# THE SHOP'S AT MERIDIAN RANCH

PHOTOMETRIC PLAN

**Shop's @ Meridian Ranch**  
Site Development Plan  
Meridian Road  
Falcon, CO

DRAWING NO. **4**  
PHOTOMETRIC PLAN

DRAWING NO.
4
 PHOTOMETRIC PLAN

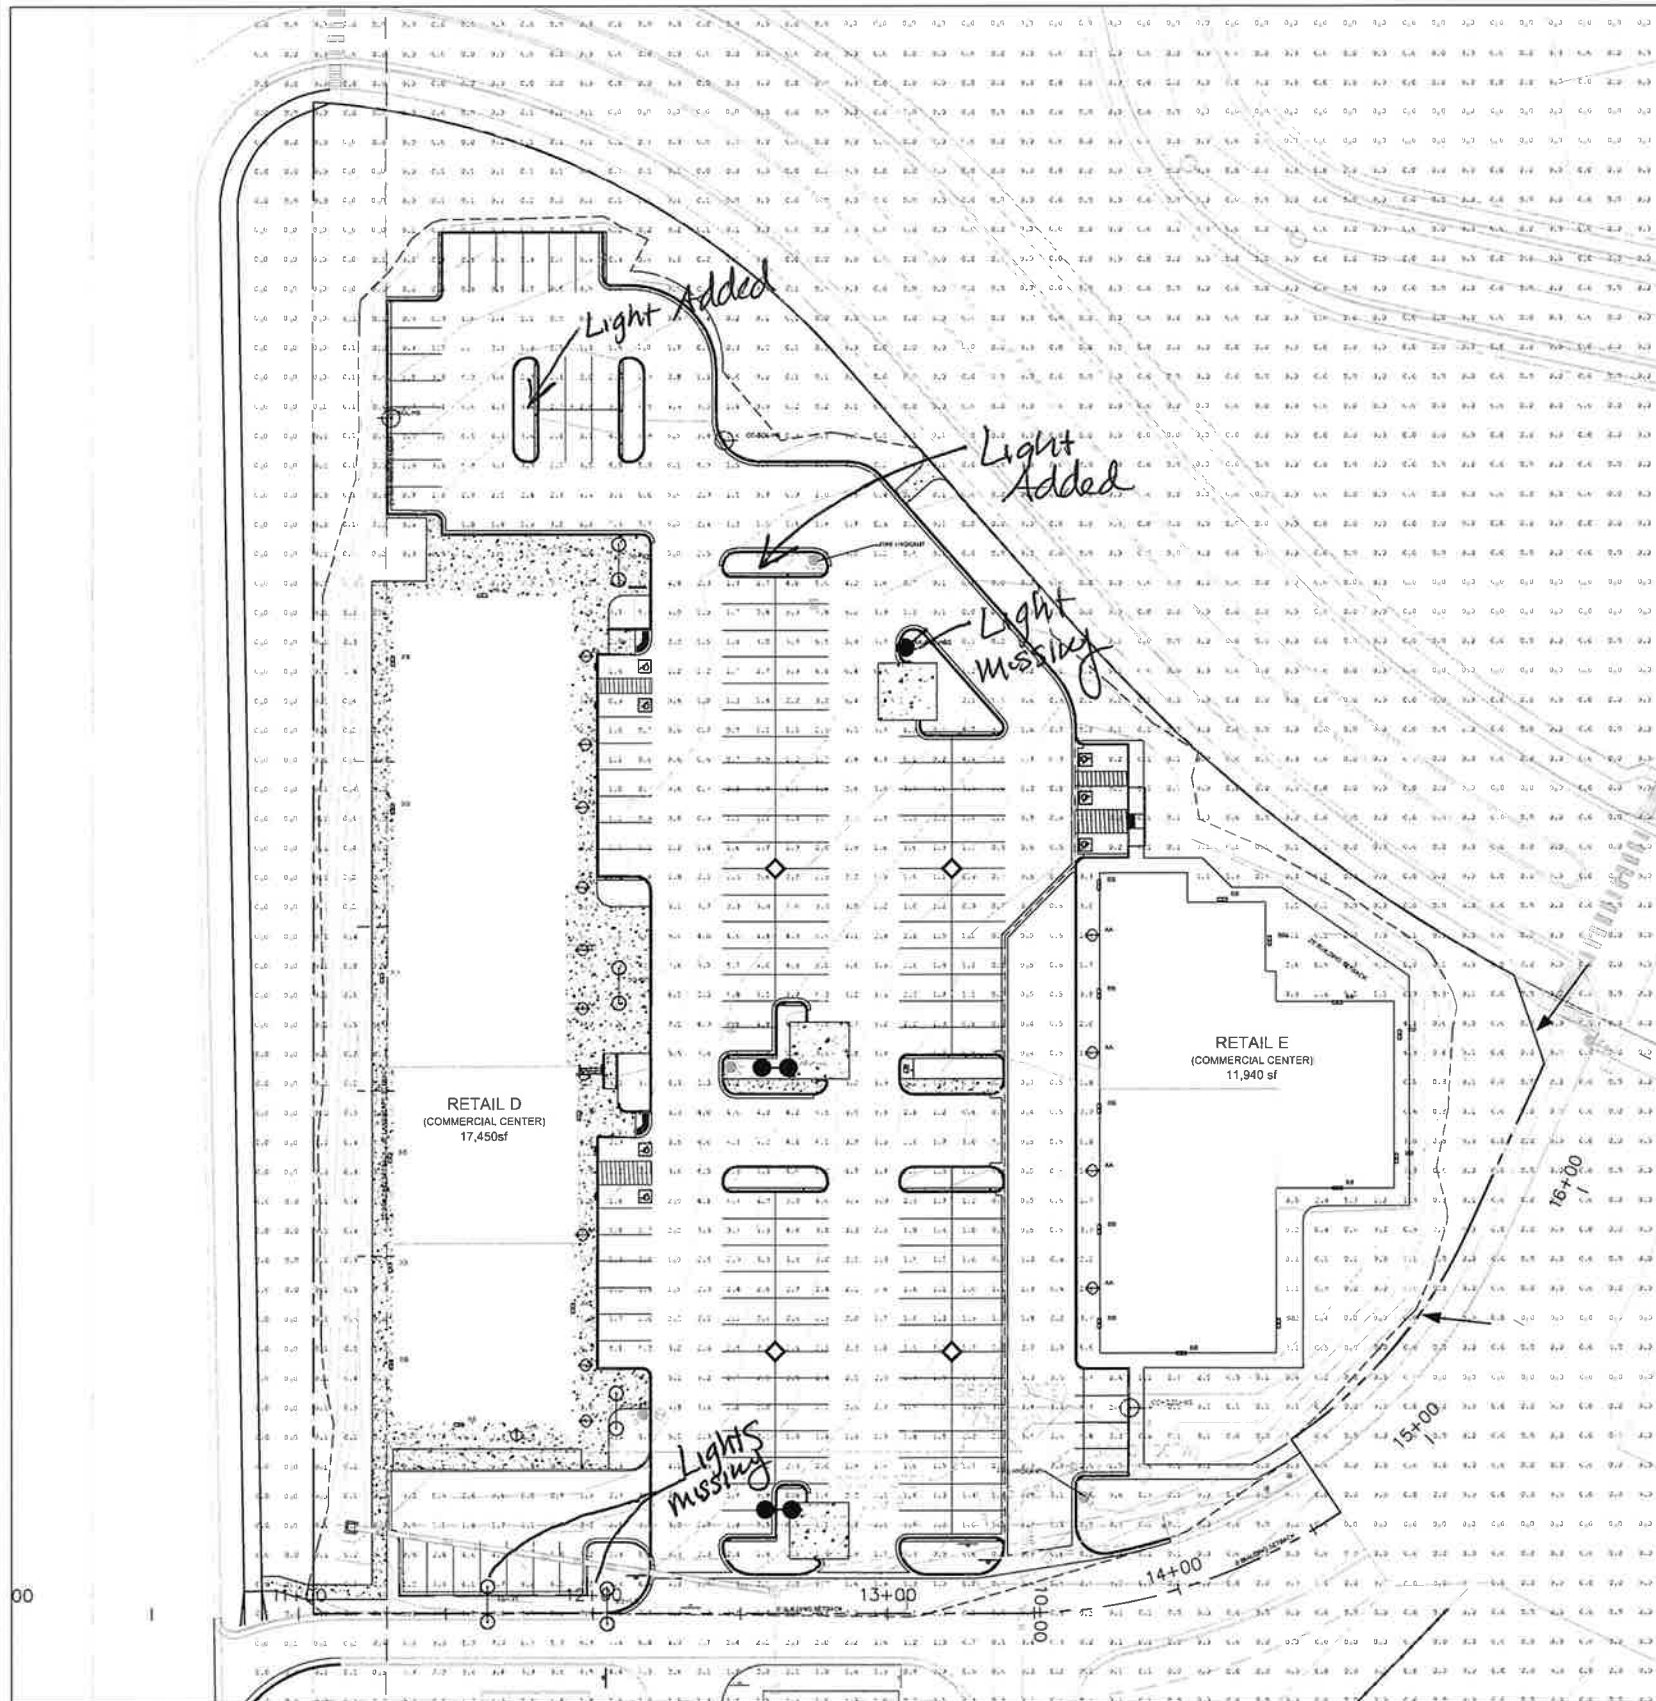
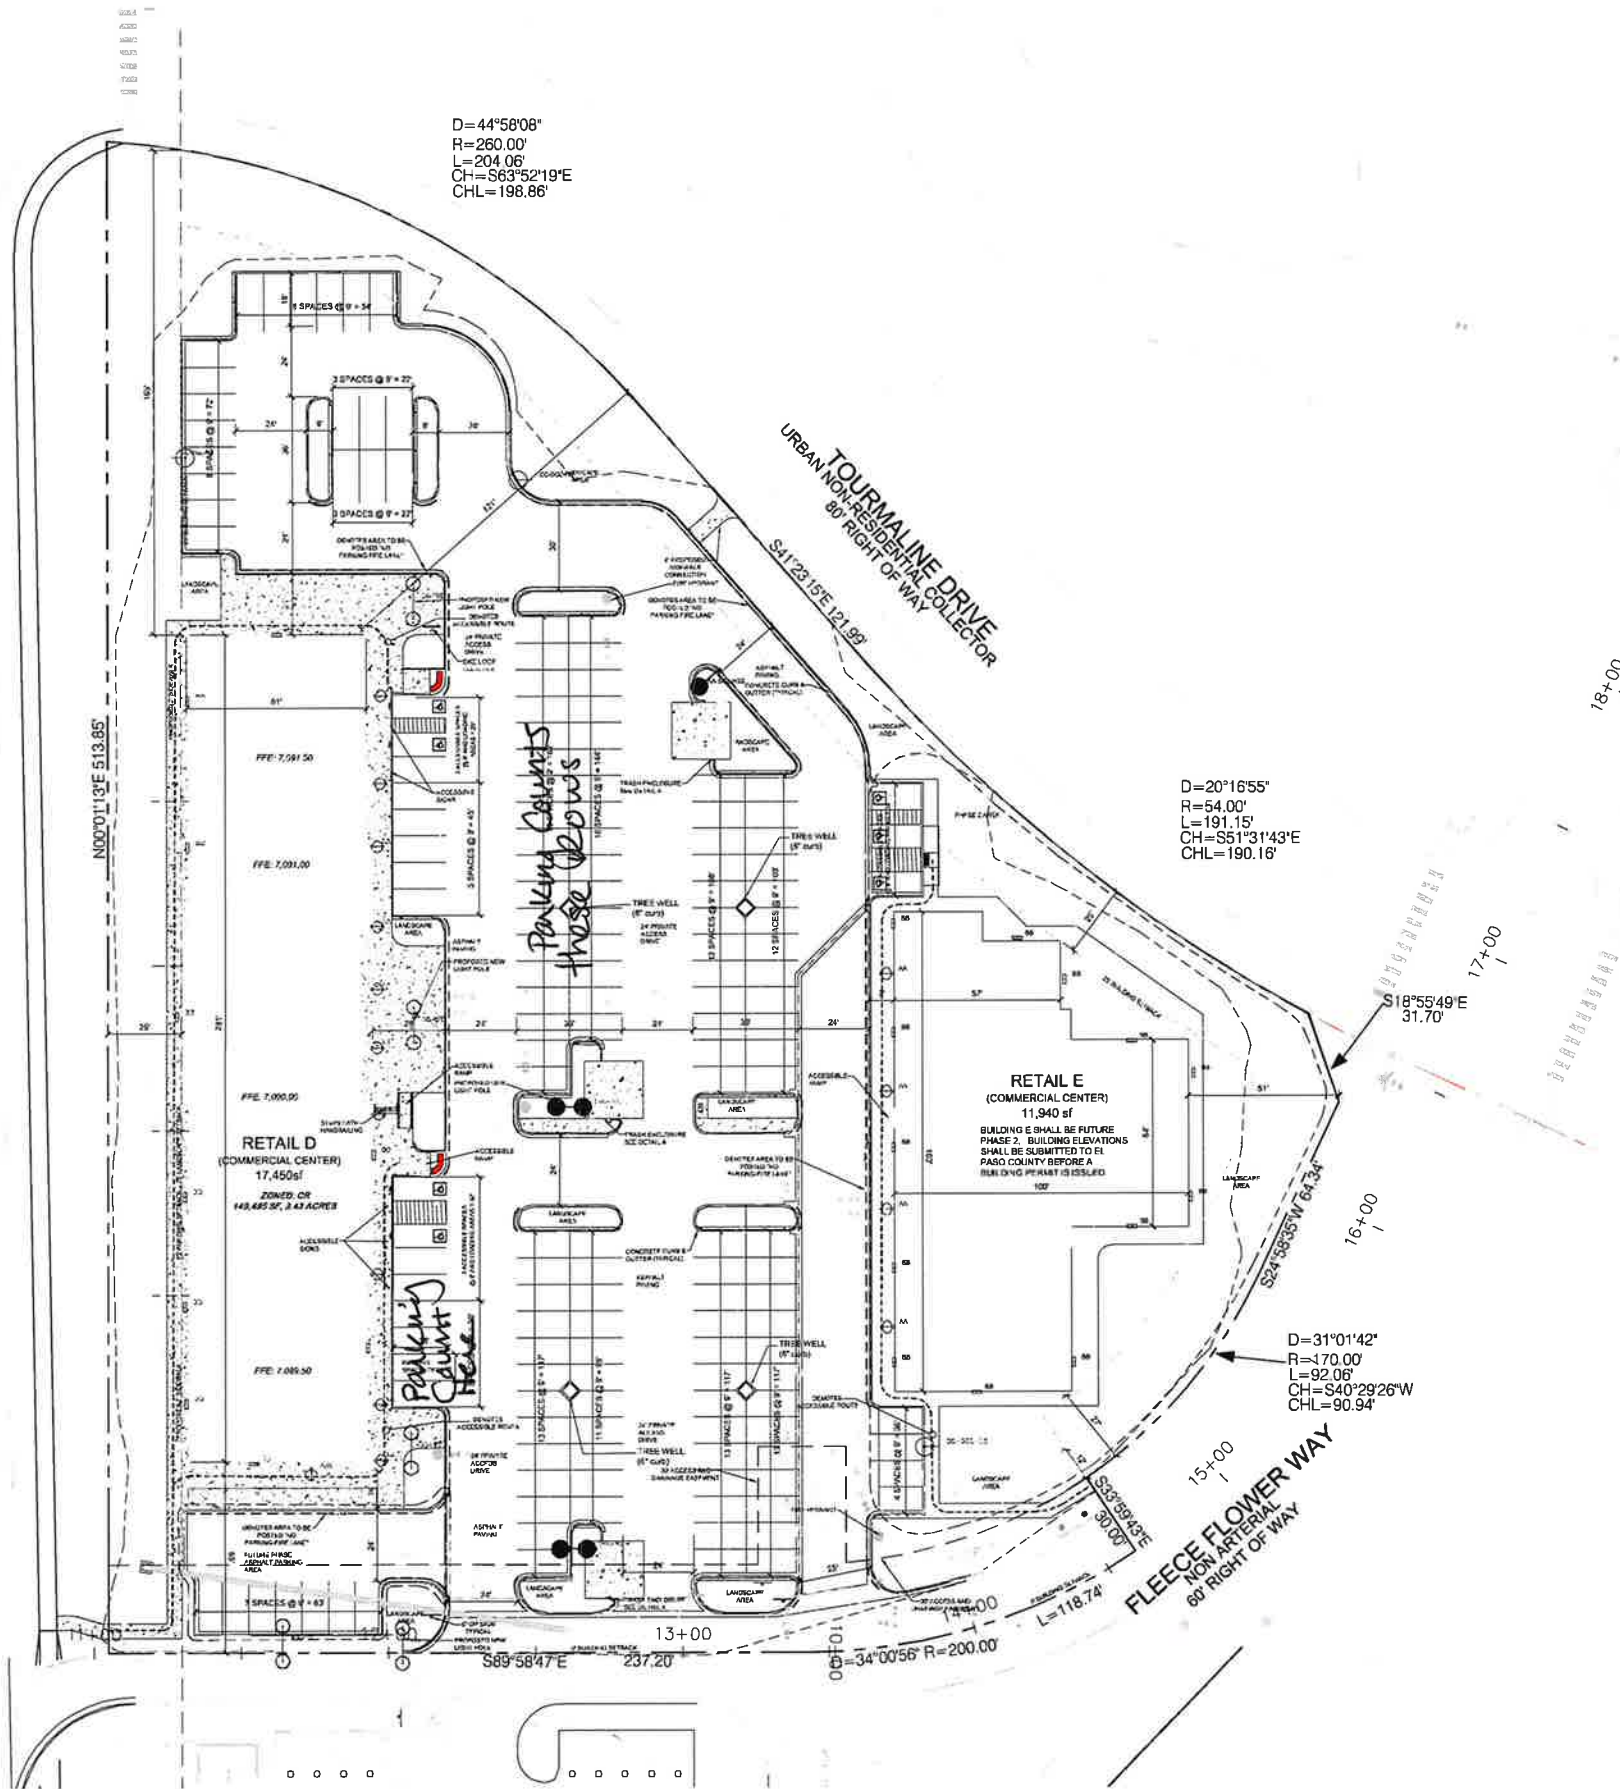
This is a public road, Land Development Code Section 6.2.3.B.e states "Light levels measured at the property line of the development site adjacent to residential property or public right of way shall not exceed 0.1 foot candles as a direct result of the on site lighting."
